Demolition of existing dwelling (No. 32) & erection of 4 No. 4 bed dwellings, alterations to existing dwelling (No. 34A) with alterations to two existing accesses to form a single point of access. This application may affect the Character & Appearance of the Ferring Conservation Area.

32 & 34A Sea Lane Ferring

Thank you for your internet representation made on 21st December 2017 which has been recorded as '**an objection**' with the comments as follows:

DRAWING TITLE
Proposed Site Plan, Location Plan
and elevation from south

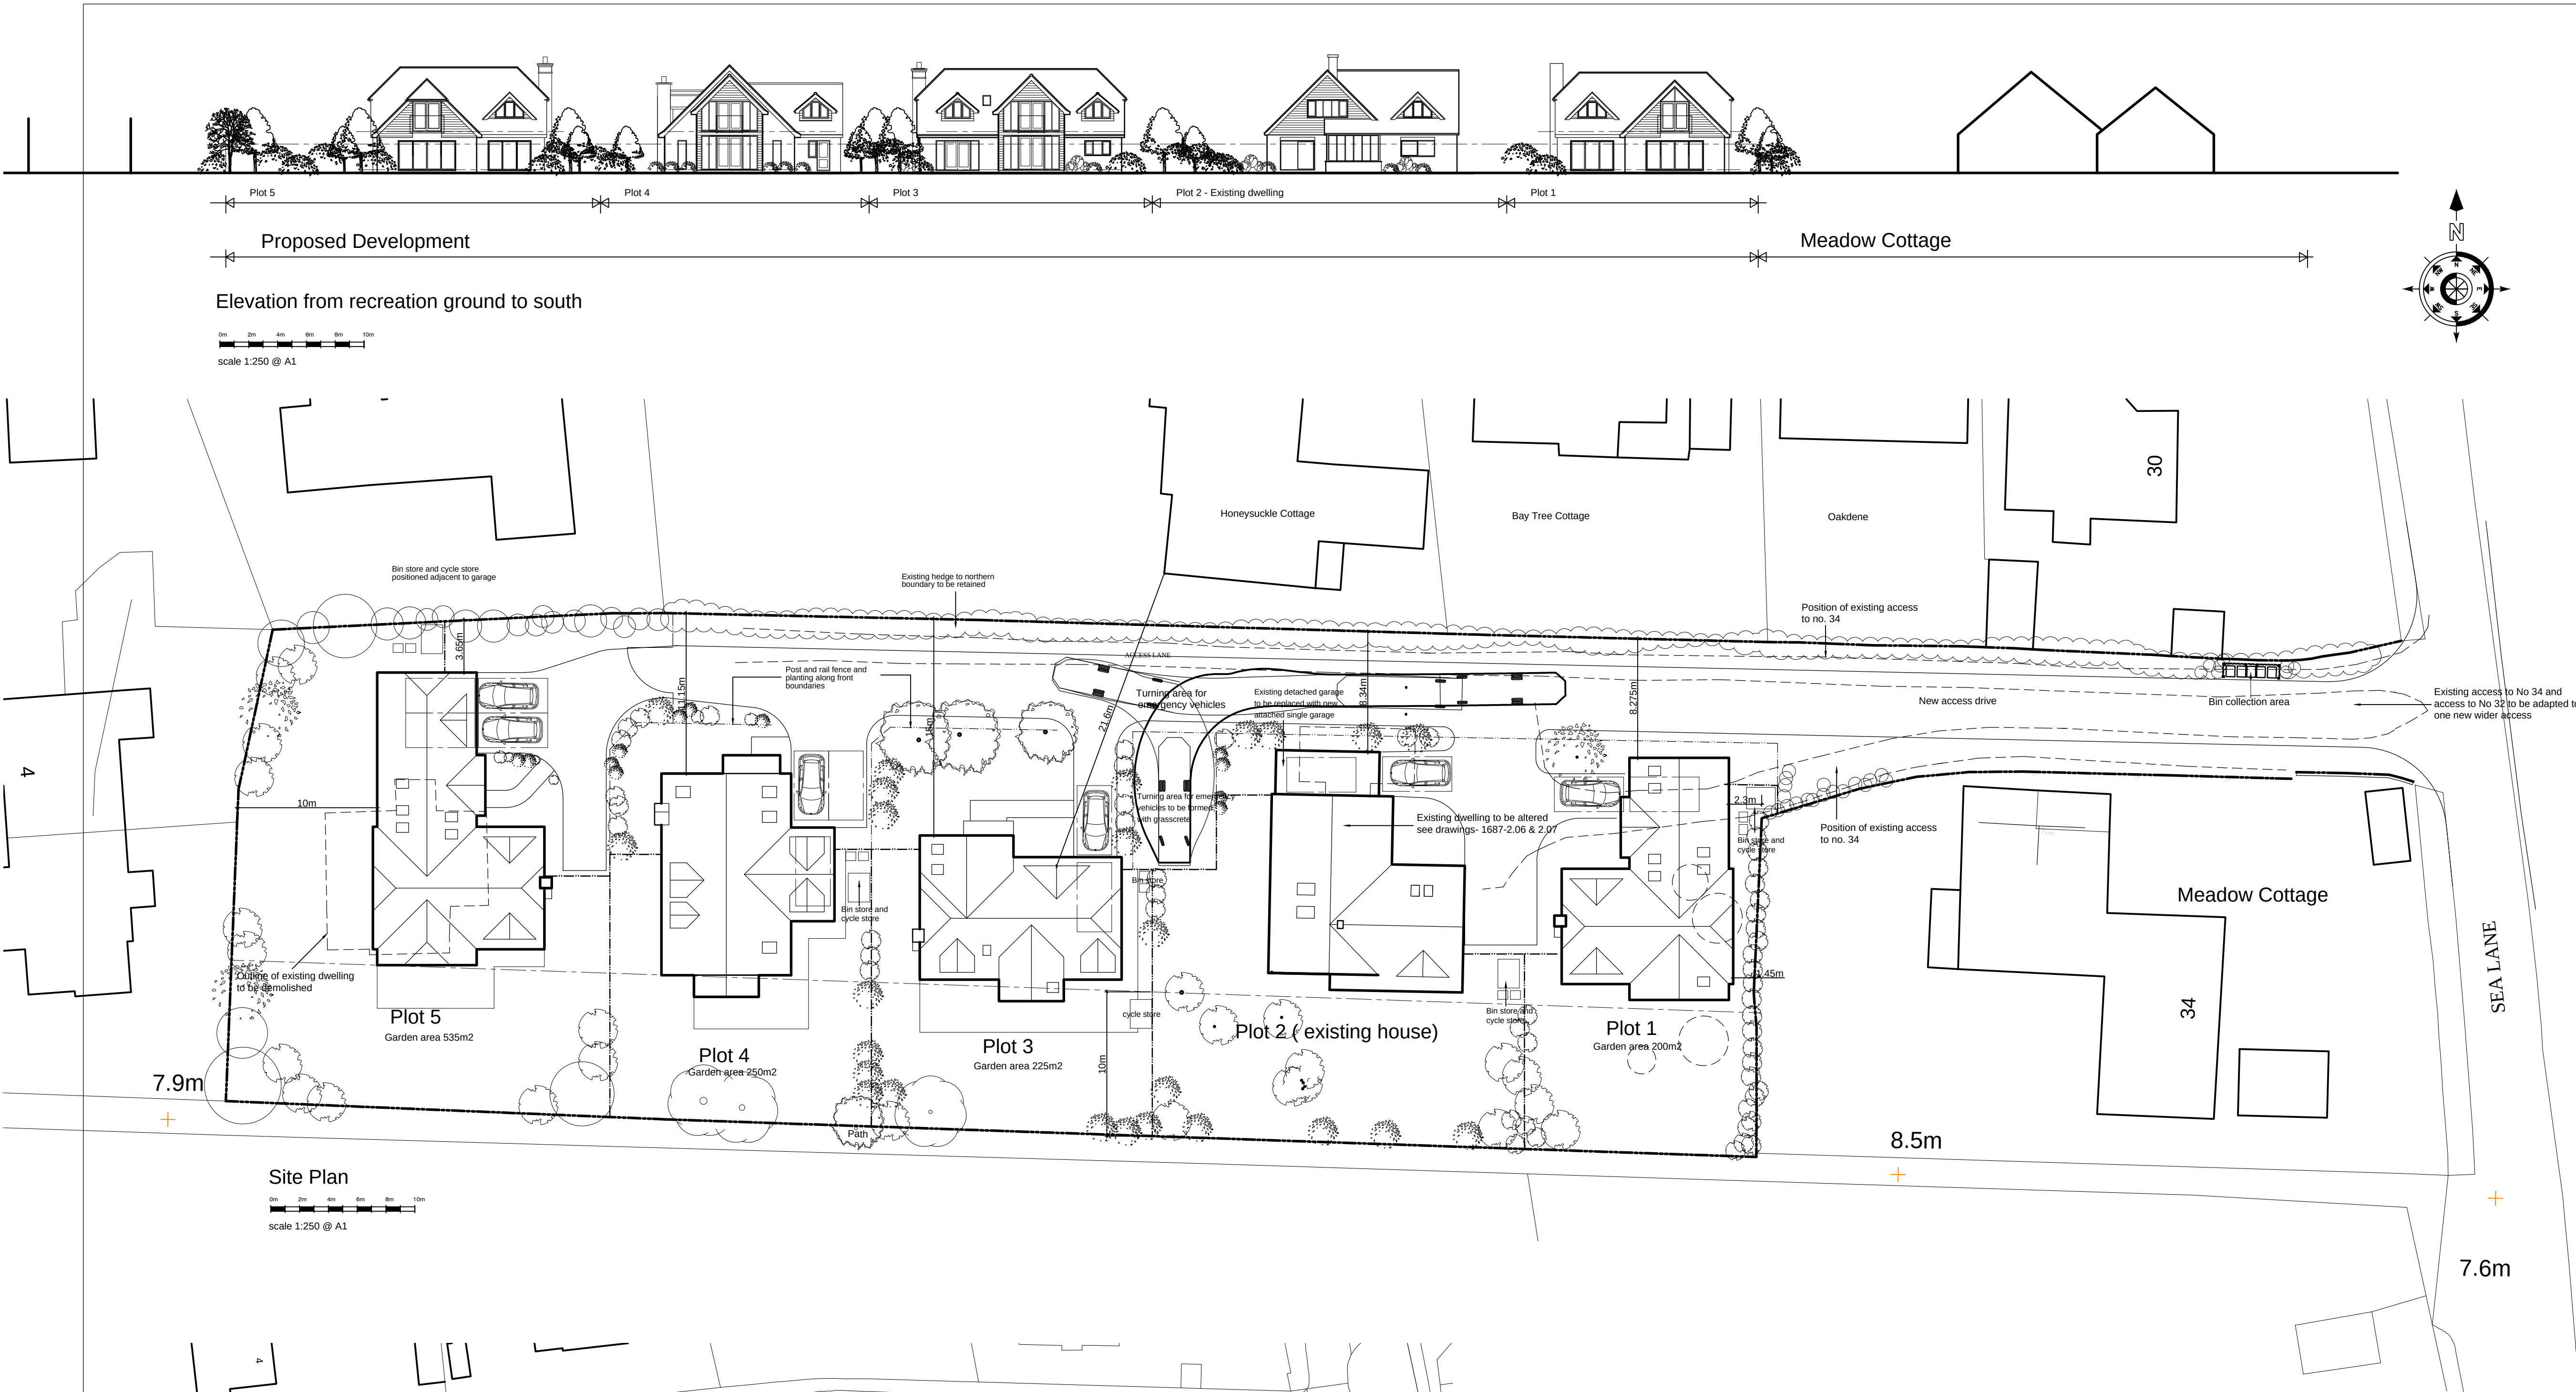
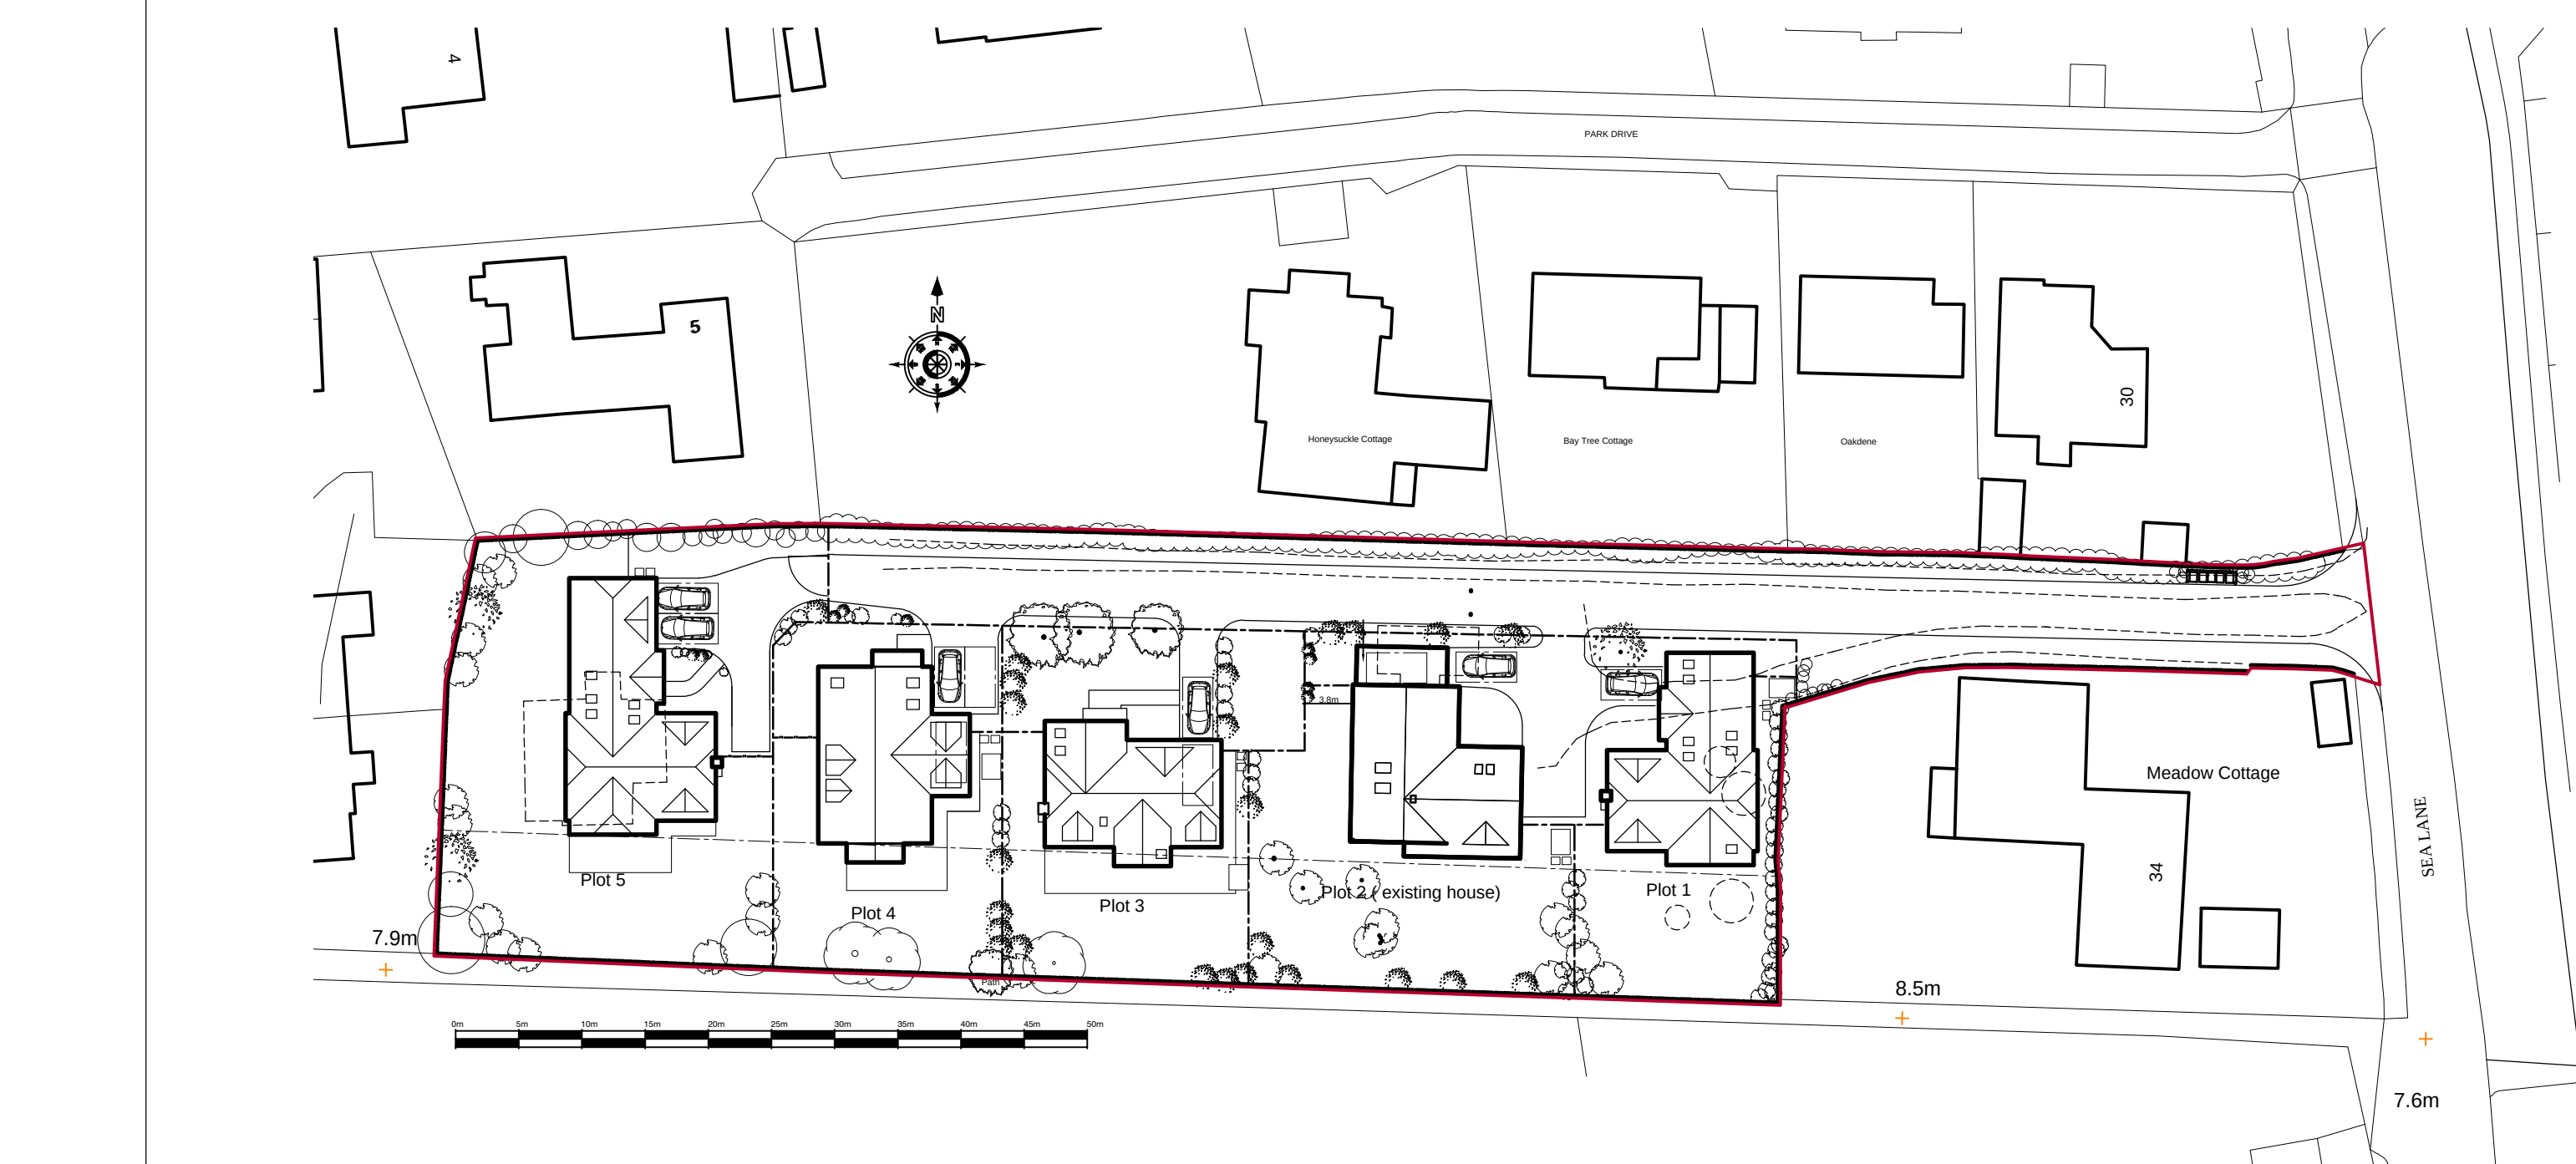
New plot 1 on the plan would be squeezed in between the Garden House and Meadow Cottage and would only be 1.4m from the boundary of Meadow Cottage and would be overly prominent. It would also starve our garden of any evening sunlight and therefore adversely affect the reasonable enjoyment of our property.

The plot currently has permission to replace dwelling on no 32 and a new property in good sized plot (in keeping with surrounding properties) in the back garden of 34a Garden House. Ref FG/37/16/OUT. Both of these properties sit within the centre of their plot and with a 10m distance from the building to shared boundary. No more houses are suited on this plot to be in keeping with the current area.

5 properties on this shared driveway would also cause additional nuisance to our property with increased traffic, both owned cars and service vehicles passing only 1.5m from our downstairs bedroom. As the properties proposed are obviously working family style homes, having 4 bedrooms, that is potentially 25 cars (once the children shortly become teenagers), 23 more than present with commutes to and from work and any recreational journeys.

Access onto Sea Lane for increased traffic will still be unsafe. The sightlines shown on the proposal cannot be guaranteed as they cross land of other properties not owned by the applicant. This is especially dangerous being so close to a school which is extremely congested at peak times. Even when not congested cars are regularly parked opposite the proposed entrance, narrowing the highway.
